RE: Oakdale West Estate – Lenore Drive / WNSLR - Response to RMS Comments

I refer to the proposed development of the Oakdale West Estate and in particular the comments received – via email – from Roads and Maritime Services (RMS) on 21 September 2018. In this regard, we have reviewed the RMS comments with our response provided in Table 1 below.

Table 1: Response to RMS Comments

Figure 5: Lenore Drive / WNSLR intersection (Additional Upgrades) – 2036 Modelling Scenario

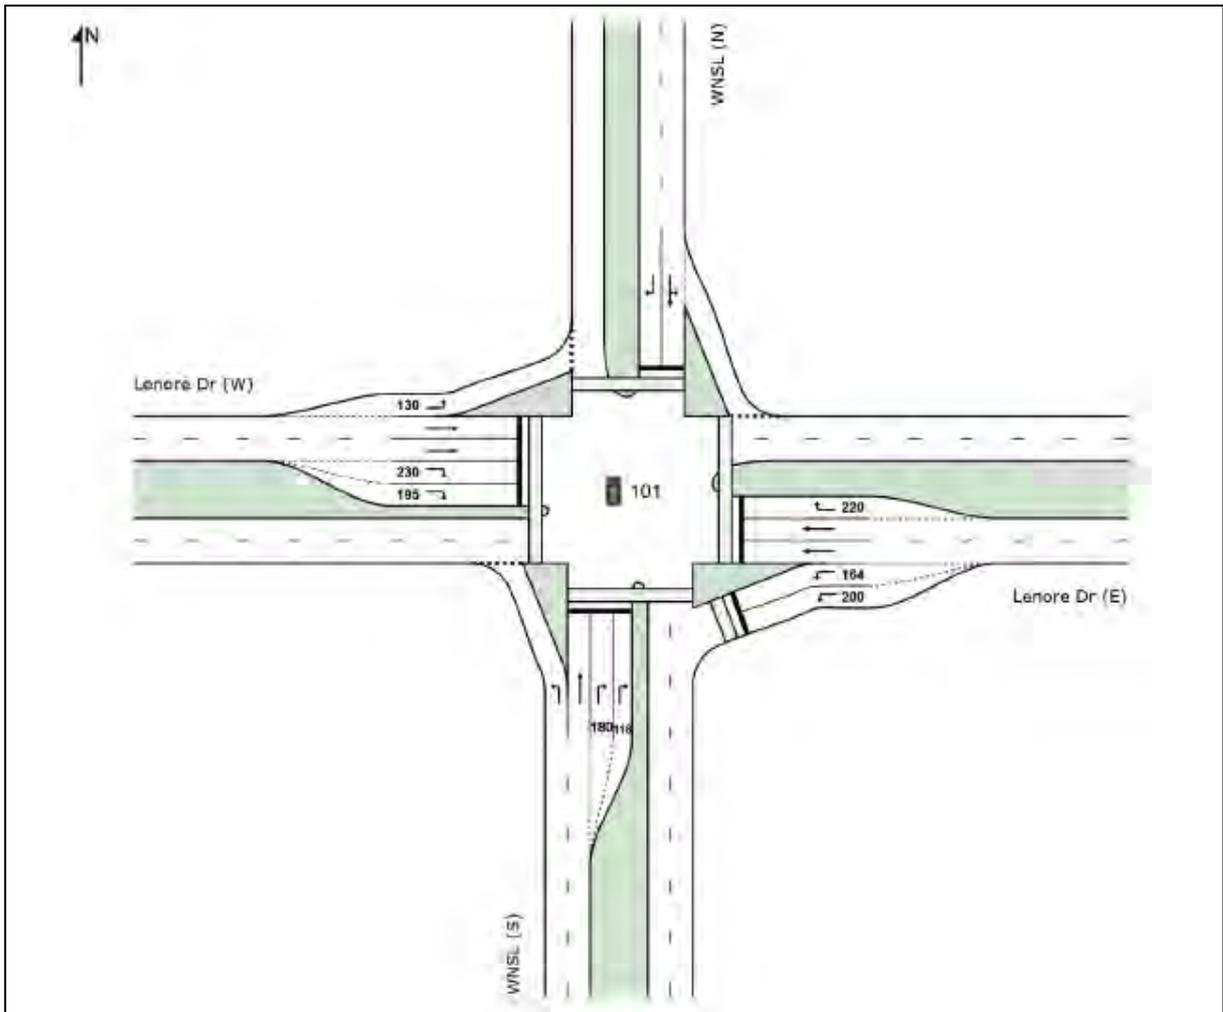
<p>Dual right out of the Western North South Link Road into Lenore Drive should cater for two 26.0m B-doubles to turn at the same time.</p> <p>Signals to operate as a double diamond phasing unless otherwise agreed to by Network Operations.</p>	<p>Dual right turn lanes in WNSLR (turning right onto Lenore Drive, eastbound) were found to be required for intersection capacity reasons.</p> <p>The updated SIDRA modelling adopts double diamond signal phasing and associated dedicated lane configurations.</p>
<p>As the dual right turn from the Western North South Link Road into Lenore Drive will be the dominate turn movement and the amount of pedestrians is expected to be very low, it may be beneficial to remove this crossing. However approval would need to be obtained from Network Operations.</p>	<p>Noted.</p> <p>It is expected that the final design of the intersection would be subject to a WAD process where this detail could be confirmed in consultation with RMS Network Operations.</p>
